CITY OF MERCER ISLAND

RE: Request for Information #3 for File No. SUB21-008 – Koneru Short Plat
6610 East Mercer Way, Mercer Island, WA 98040; King County Tax Parcel # 302405-9153

The City of Mercer Island reviewed your third submittal for SUB21-008. Following the review of the materials, City staff has determined that additional information is necessary to ensure compliance with the Mercer Island City Code (MICC). The following items will need to be addressed at your next submittal:

C1.0
SHEET

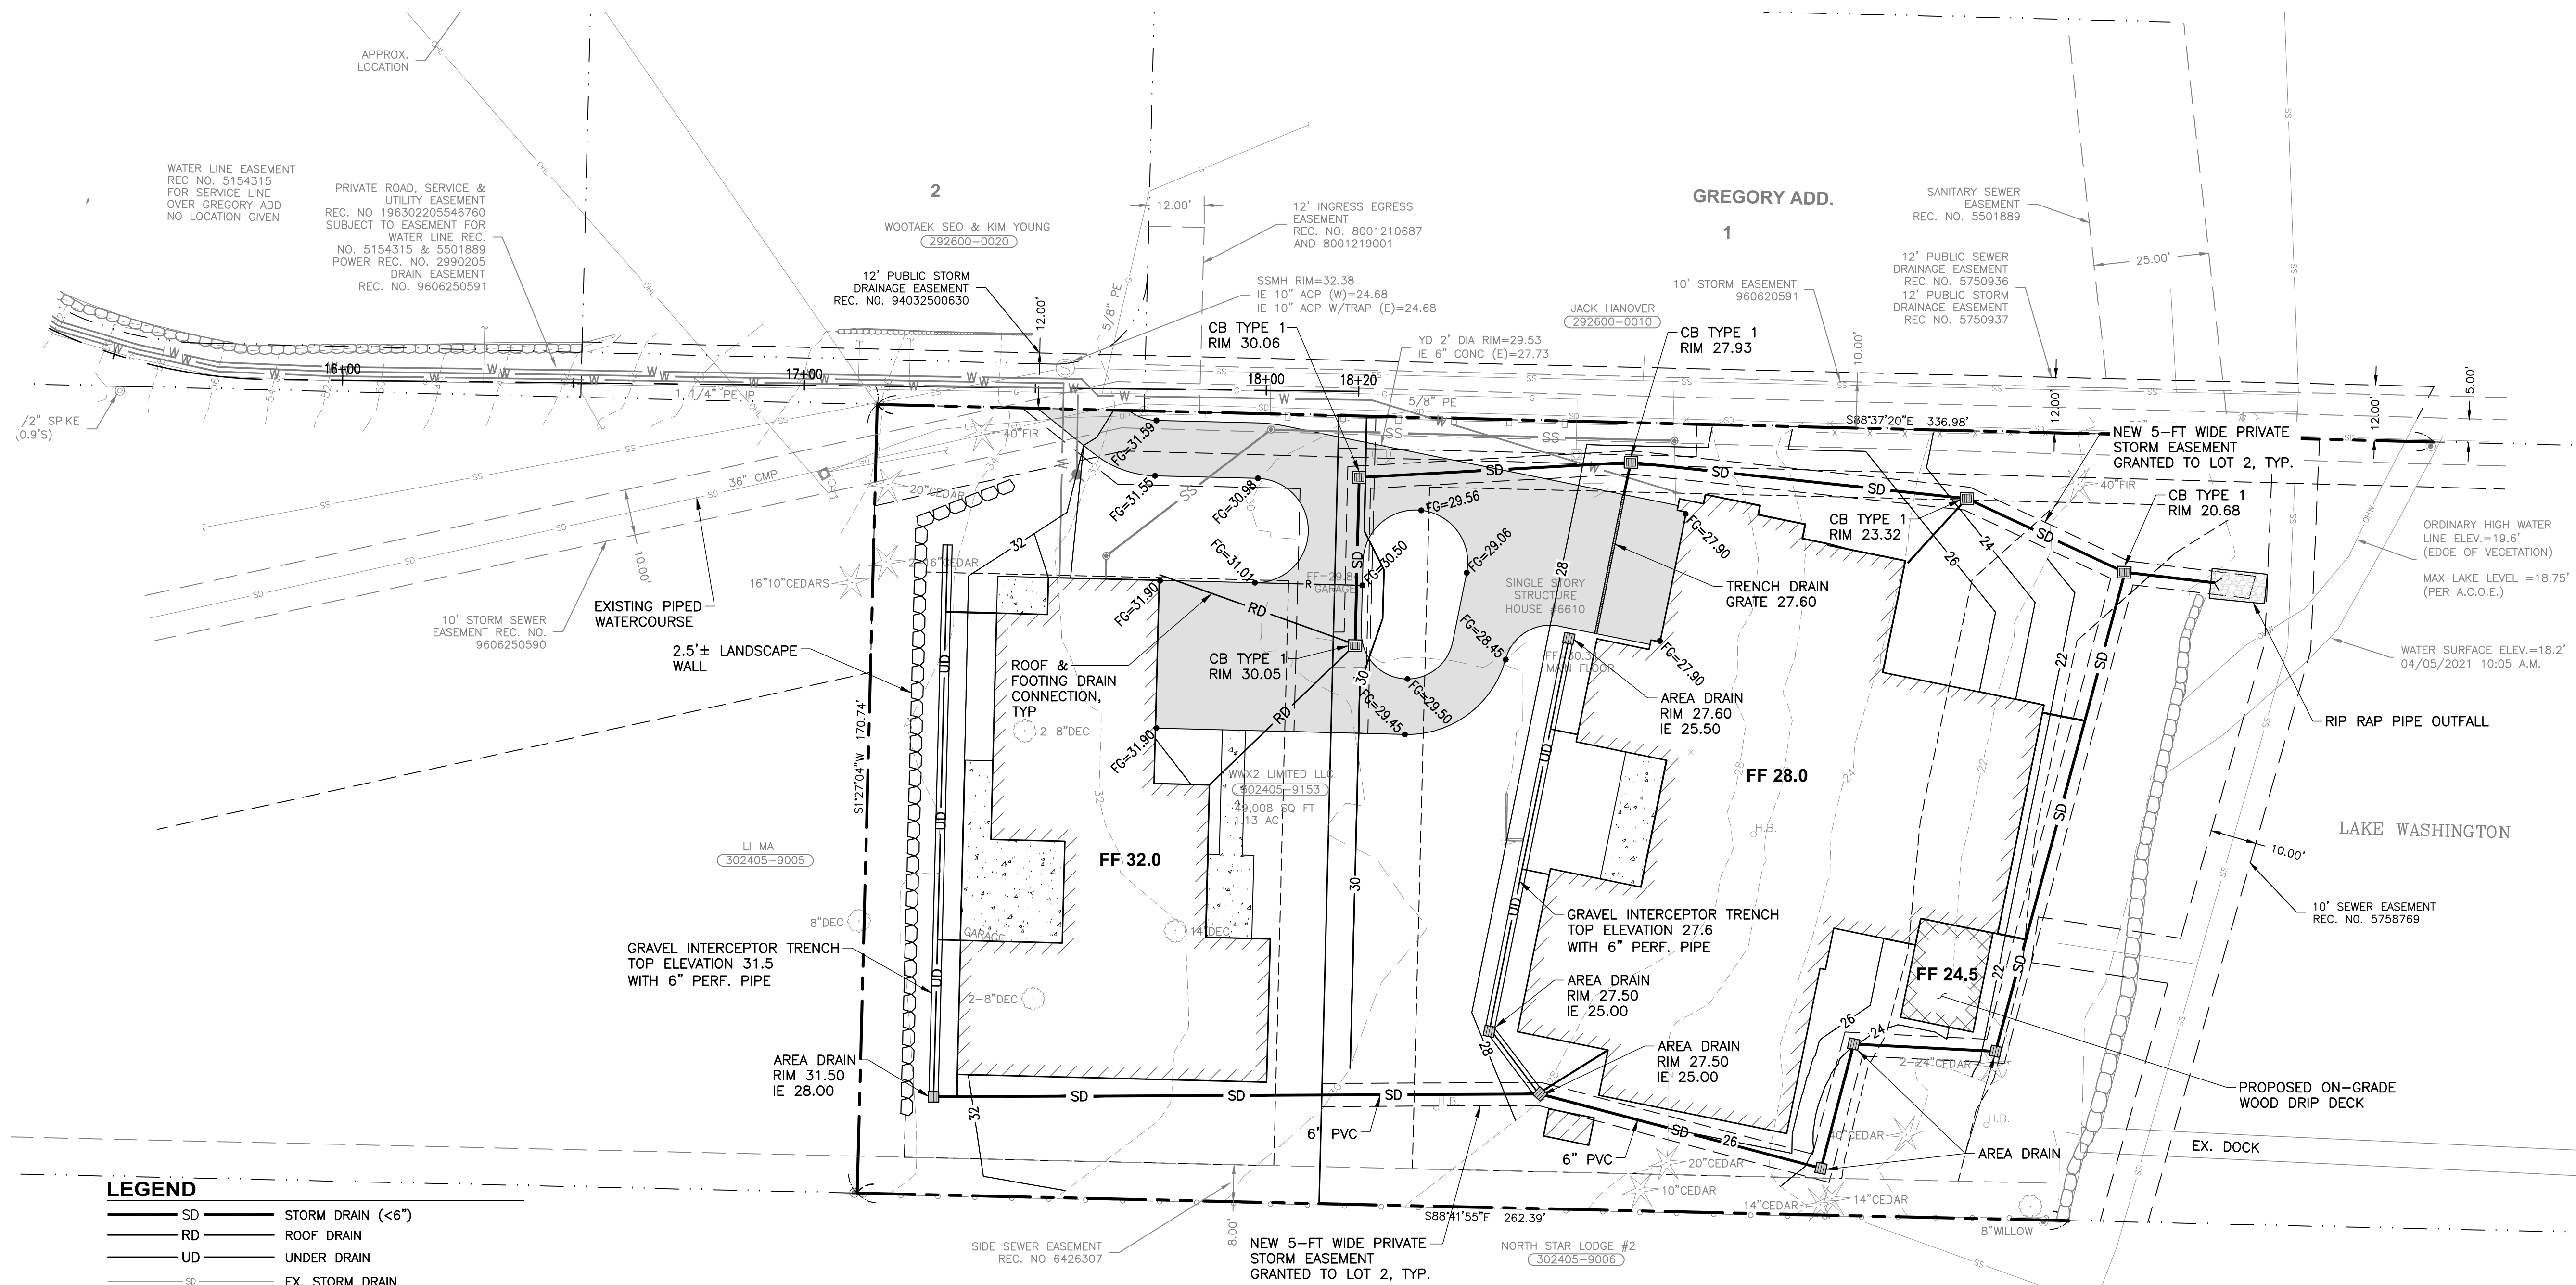
1. Please see the attached plan review set, all engineering comments are provided in the document.
2. There is an existing public sewer easement onsite near the shoreline with recording number 5501889, please show on the plan.

3. The private 5-ft wide storm drainage easement and drainage system cannot be inside the public sewer easement near the shoreline, it is unable to verify due to the missing easement (recording # 5501889) with this submittal.

4. Please clarify if the 5-ft storm easement near the northern property line is private or public, and proposed or existing.
5. Please clarify if the 7-ft side sewer easement for Lot 2 granted to Lot 1 is private.

6. Please clarify if the new 16-ft wide shared access and utility easement is private.
7. Please clarify if the access easement for Lot 1 granted by Lot 2 is private, also provide dimensions and limits of this easement. The submitted plan does not show the limits, only the call out.

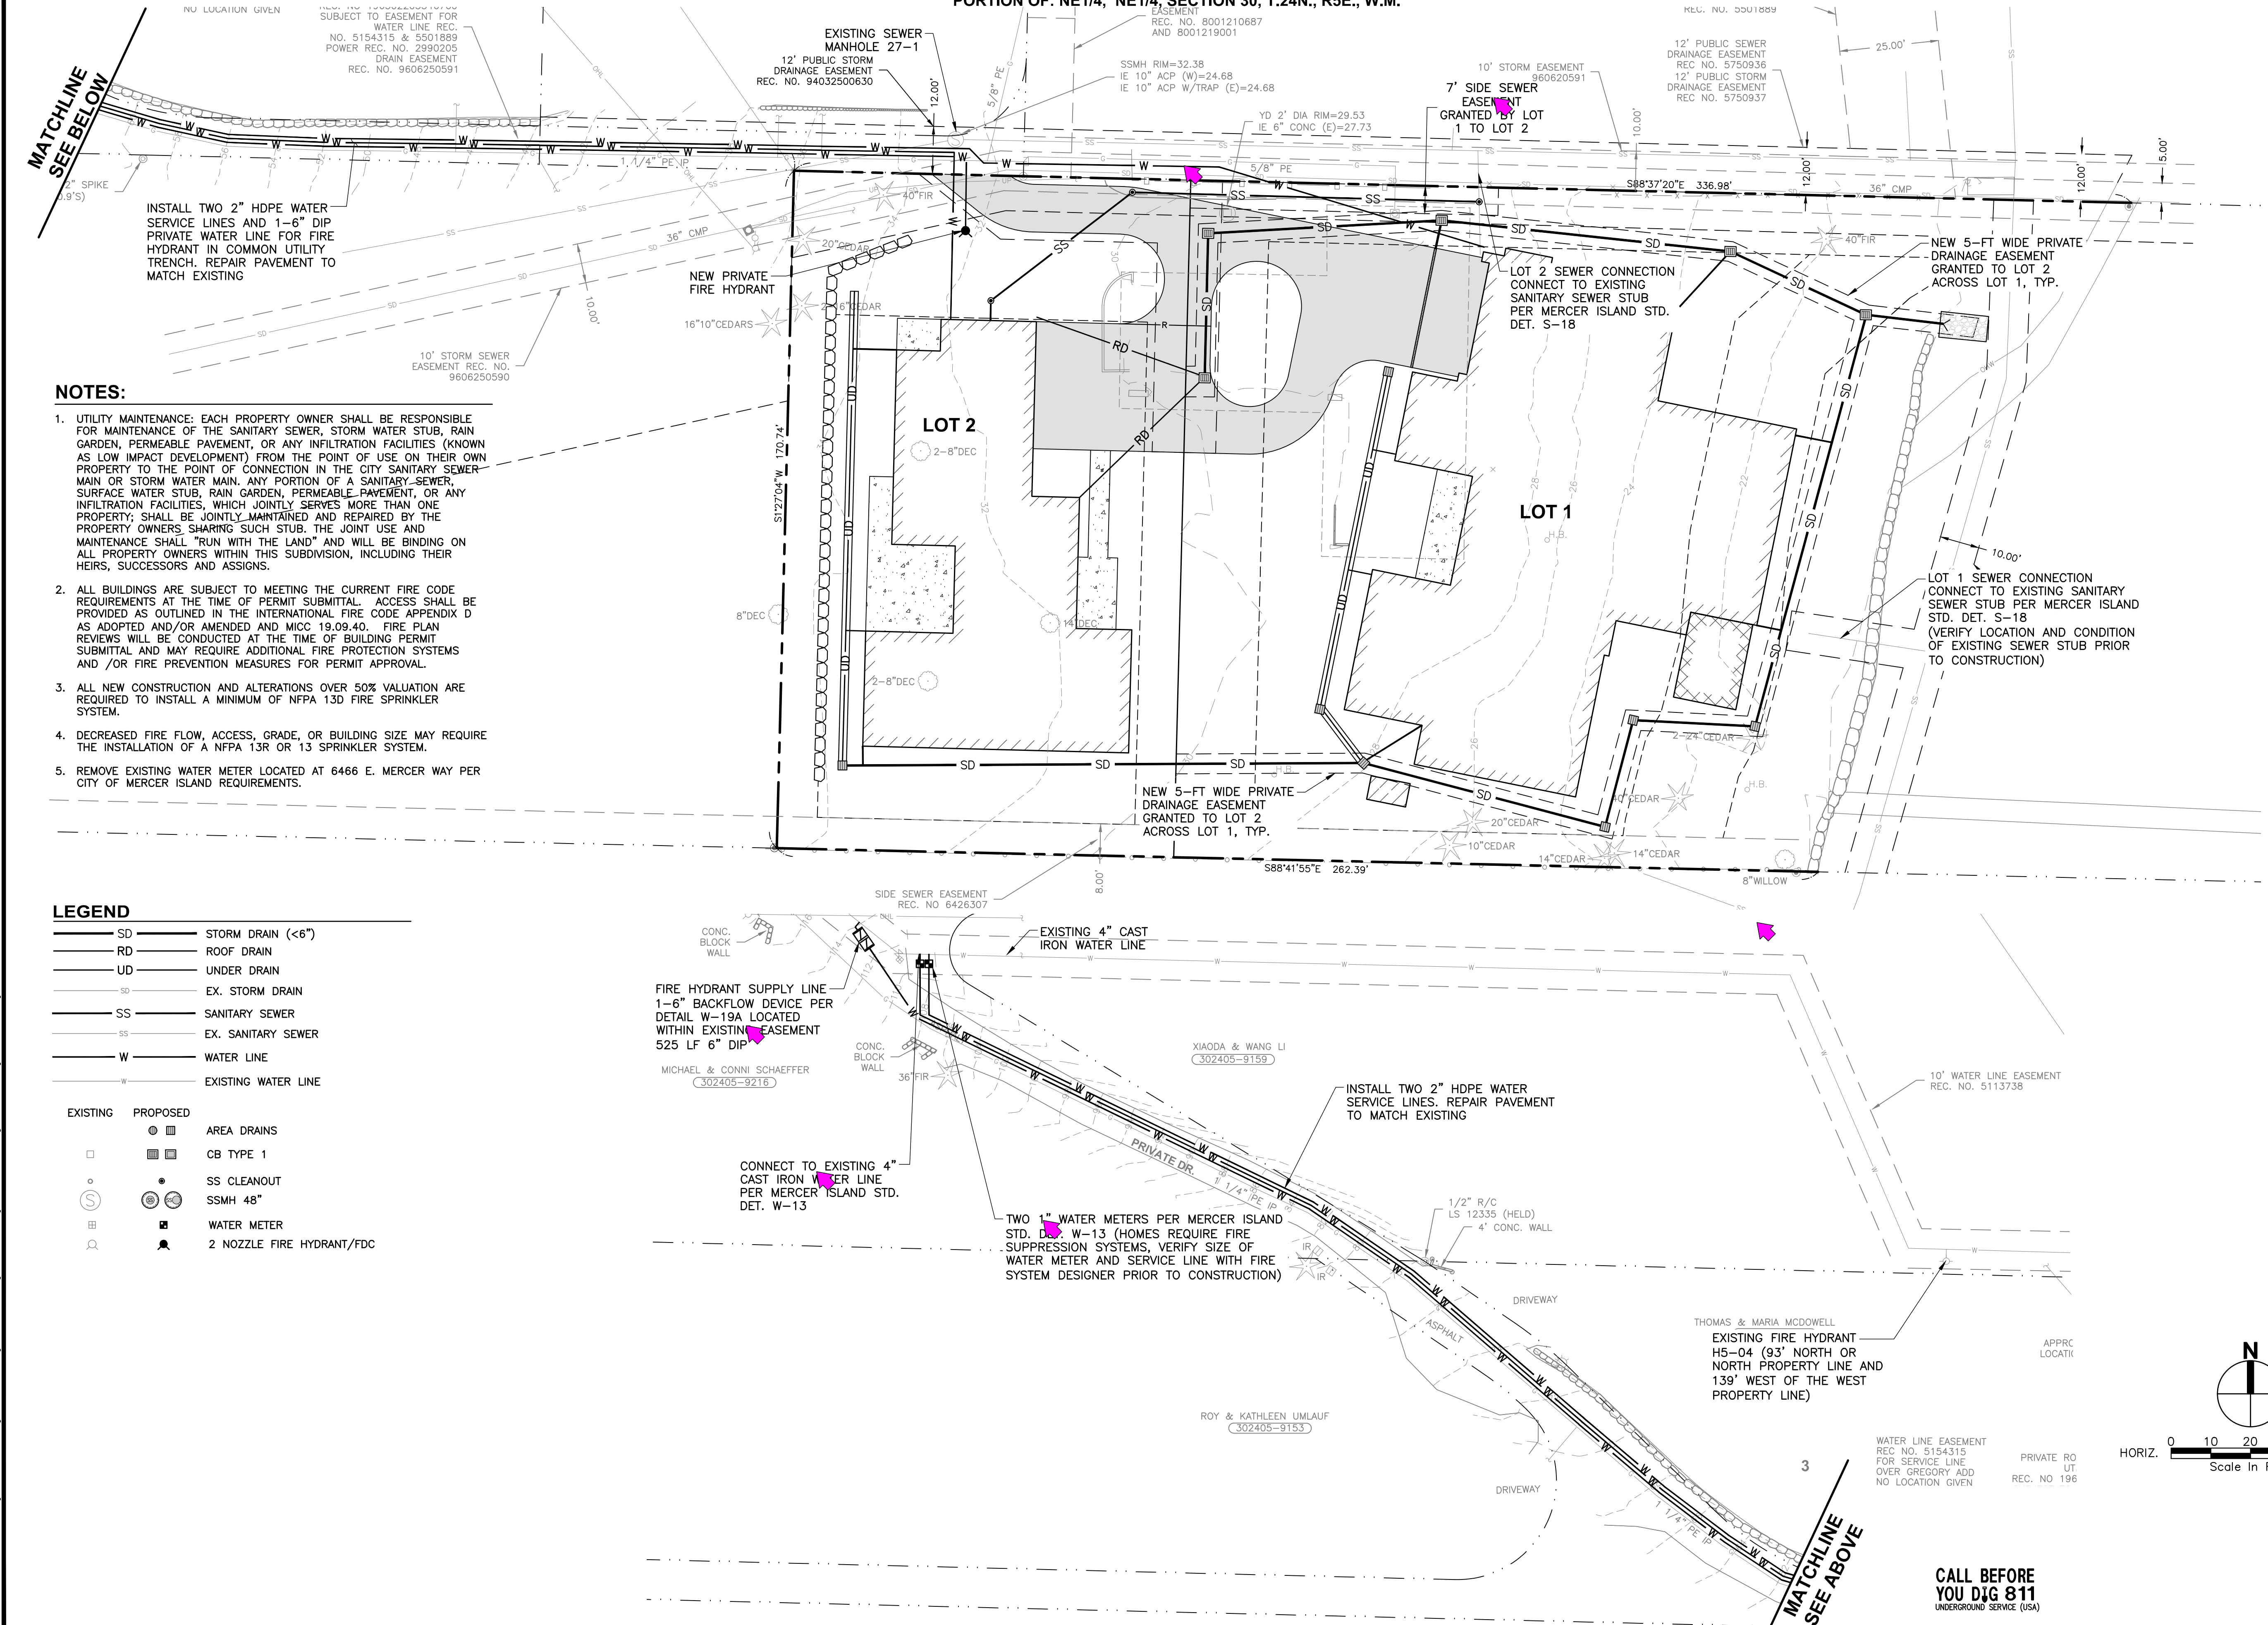
6. Hydrant spacing- Proposed Fire Hydrant, must meet standards

IFC C102 Number of Hydrants and spacing required. Hydrants shall be located within 250 feet from the hydrant to the fire department access. Additionally, fire hydrants shall be located within 300 feet from the furthest point of the residence (w/o fire sprinkler system) and 600 feet (with sprinkler system).

7. Waterflow- Does not meet standards

This may be corrected with the installation of the proposed fire hydrant. The hydrant shall be calculated/modeled to provide at least 1500gpm. Additional flow may be required depending on the house size and construction as listed in IFC B102.

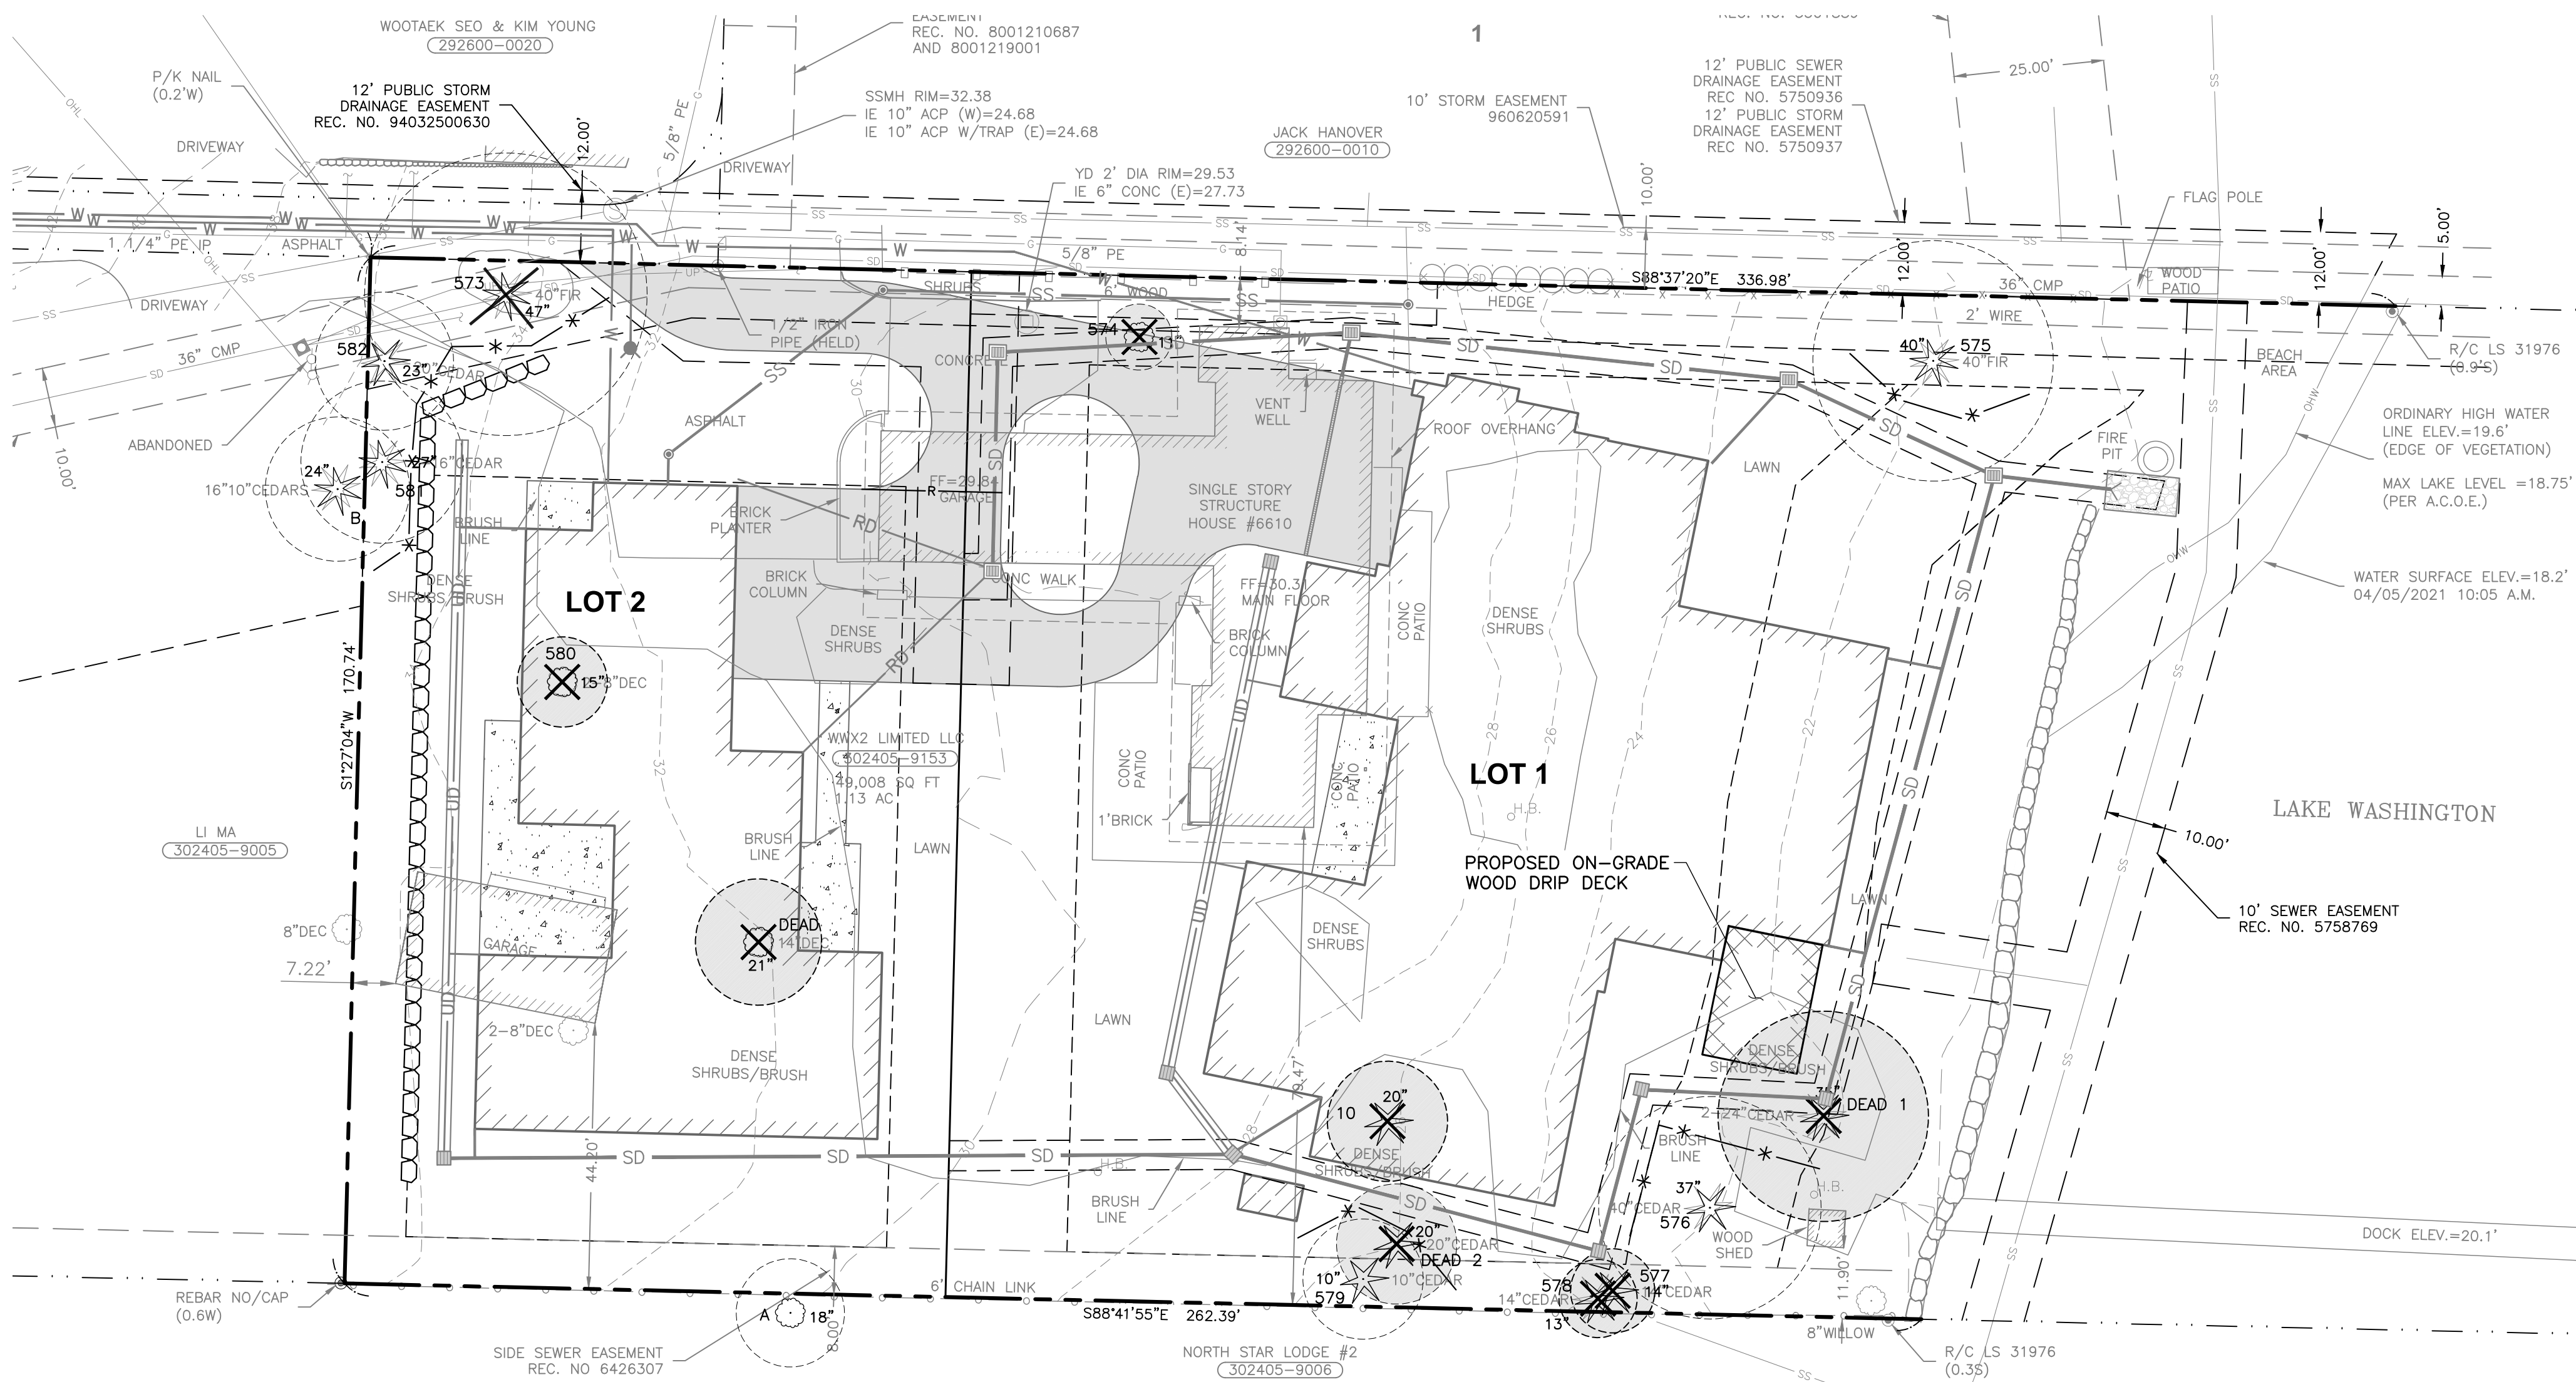
1. (Repeat comment for Architect/Arborist) Provide the tree inventory worksheet and include all trees removed within five years. This will include the trees that were approved to be removed under the non-development tree permit before this development proposal. This was for five trees to be removed under permit 2104-048 (trees 6,7,8,10,15 in previous report). The tree protection plan must show at least 30% of trees being protected and not damaged by construction for this subdivision to be approved. https://www.mercerisland.gov/sites/default/files/fileattachments/community_planning_amp_development/page/21988/mercerislandtreeinventory.pdf
2. (Second repeat comment for arborist/civil) Update Arborists tree report, a draft report has been submitted. Arborist will need to review new plans and confirm the distance of disturbance is adequate and will not damage the saved tree.
